PLANNING CONSULTATION RESPONSE

Application No	2026/0420
Proposal	Erection of 10no. 2 and 3 storey detached dwellings
Address	Land west of Sheffield Road, Birdwell, Barnsley
Date of Consultation Reply	05/08/2026
Consultee	Katie Lawrence, Planning Ecologist

LOCATION PLAN
SCALE 1:1250

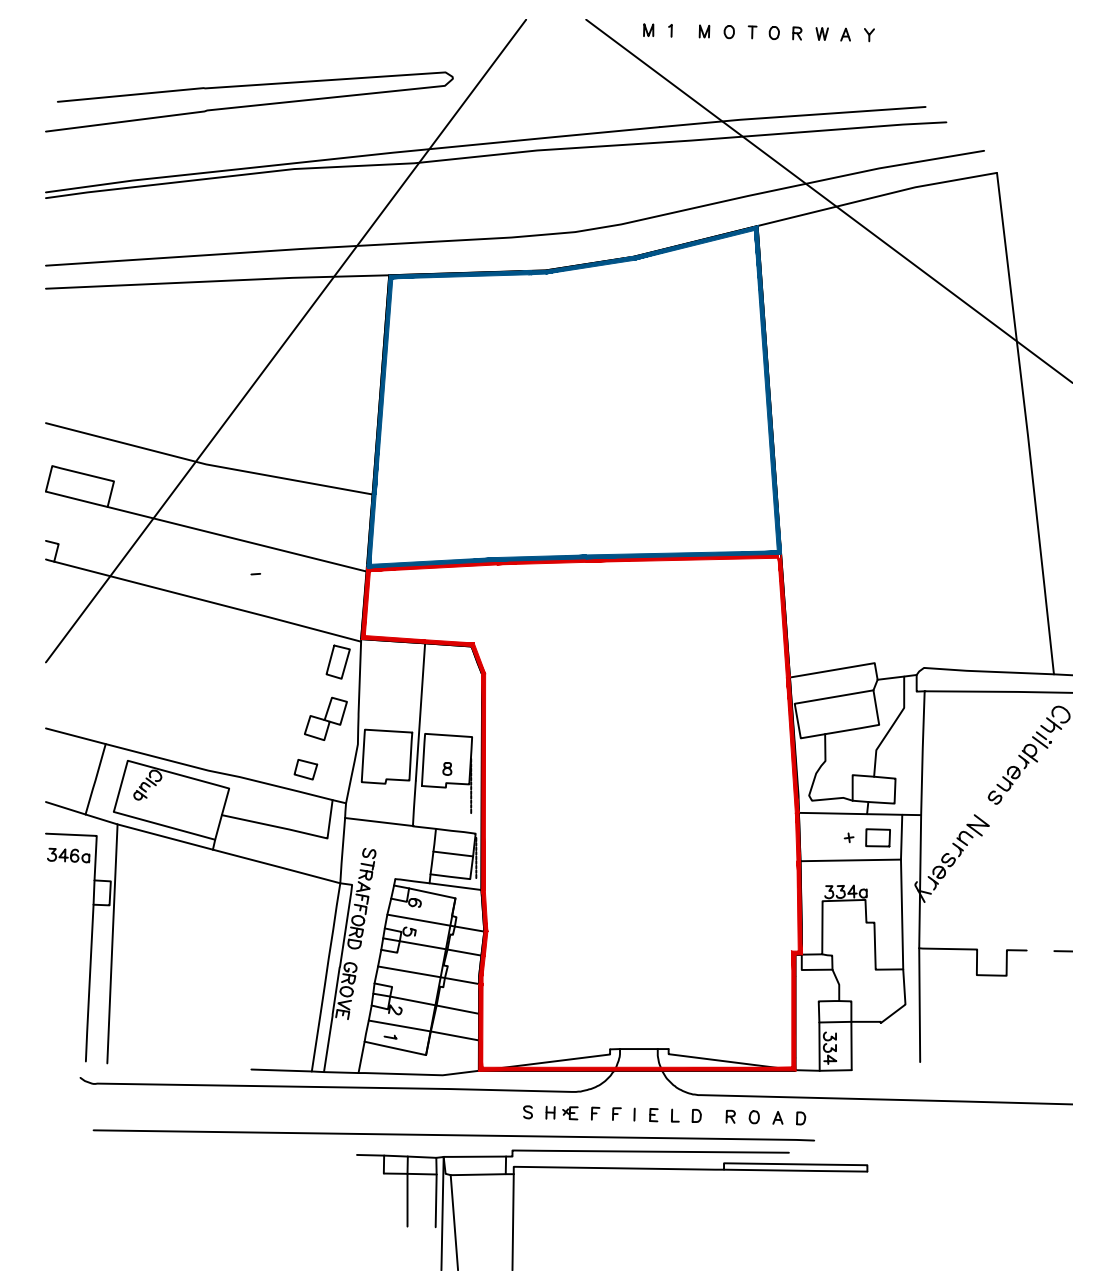
- It is noted that the metric and baseline habitat map within the PEA accounts for habitats within the red line and blue line boundary. The metric should be amended so that areas within the proposed development site are dealt with within on-site tabs of the metric and areas within the blue line are included within off-site tabs, if off-site habitat enhancement/creation is proposed. Reference should be made to the site plan submitted as part of the application (drawing ref: 24-057, 01, D) to ensure the red line and blue line boundaries match.

Appendix VI. ANNOTATED MAP OF THE SURVEY AREA.

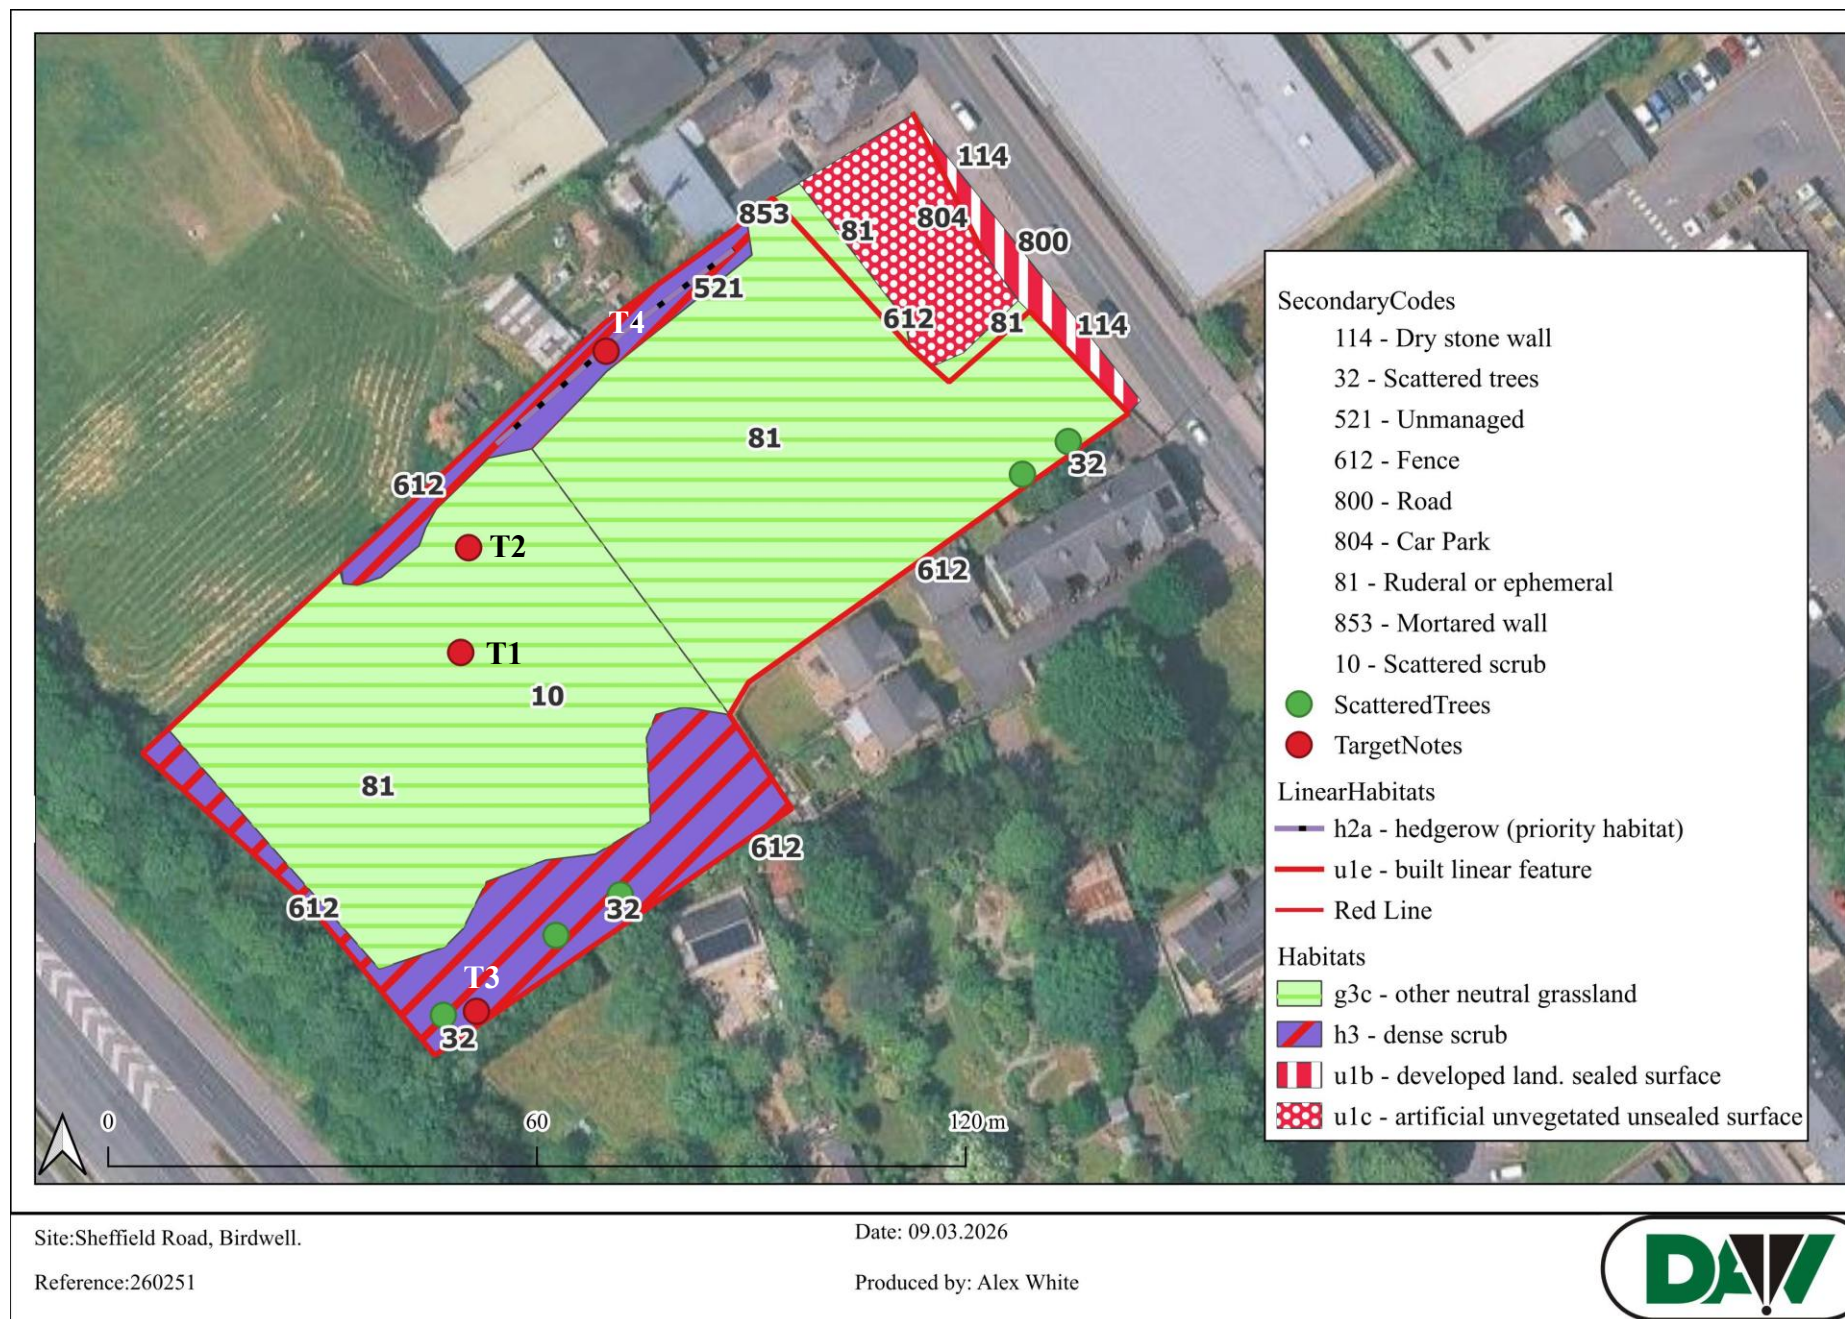
- Habitats on site largely comprise unintensively managed grassland and scrub, with occasional broadleaf trees. When referring to the governments MAGIC website, the site is mapped as Open Mosaic Habitat on Previously Developed Land (OMH), a habitat of principal importance under Section 41 of the Natural Environment and Rural Communities (NERC) Act 2006. Historical maps dated between 1951-1975 show the site previously formed part of a railway line indicating why the site has been mapped as OMH. Planning policy BIO1 of the Local Plan states that "Development will be expected to conserve and enhance the biodiversity and geological features of the borough by: Protecting and improving habitats, species, sites of ecological value and sites of geological value with particular regard to habitats of principal importance identified via Section 41 of the Natural Environment & Rural Communities Act 2006..." The applicant's ecologist should assess the habitats on site against the JNCC definition and criteria of OMH (<https://data.jncc.gov.uk/data/a81bf2a7-b637-4497-a8be-03bd50d4290d/UKBAP-BAPHabitats-40-OMH-2010.pdf>). As the initial walkover survey was carried out during sub-optimal timings, an updated botanical survey of the site should be undertaken to robustly assess the habitats present.
